PLANNING CONSULTATION RESPONSE

Application No	2025/0717
Proposal	Erection of 1.8m boundary wall (retrospective)
Address	2 Shire Oak Drive, Elsecar, Barnsley, S74 8HU
Date of Consultation Reply	27.10.2025
Consultee	Charlie Atkinson Design & Conservation Apprentice

Drawing Title
SHIRE-ELE-WH

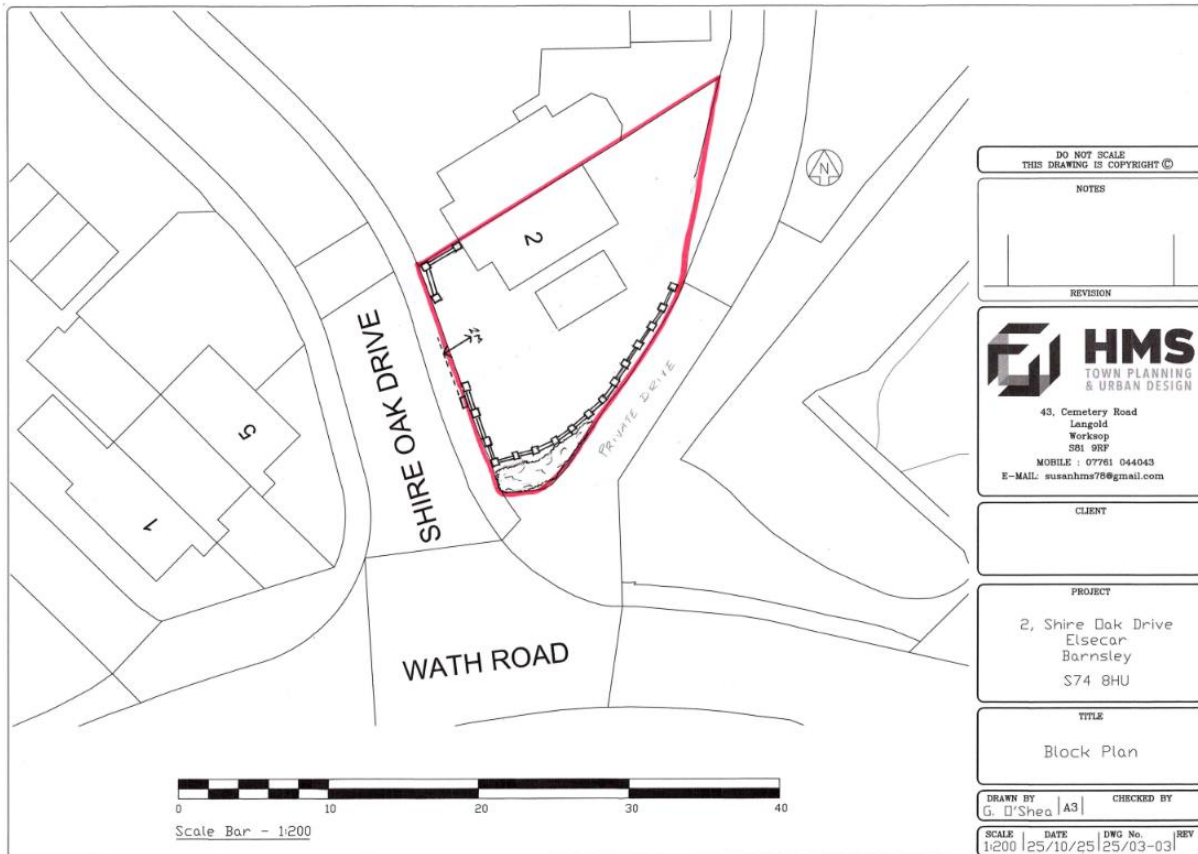
Therefore, from a conservation perspective, the retrospective application for a 1.8m predominantly stone boundary wall is deemed acceptable due to its traditional and sympathetic appearance, which complements the surrounding modern development.
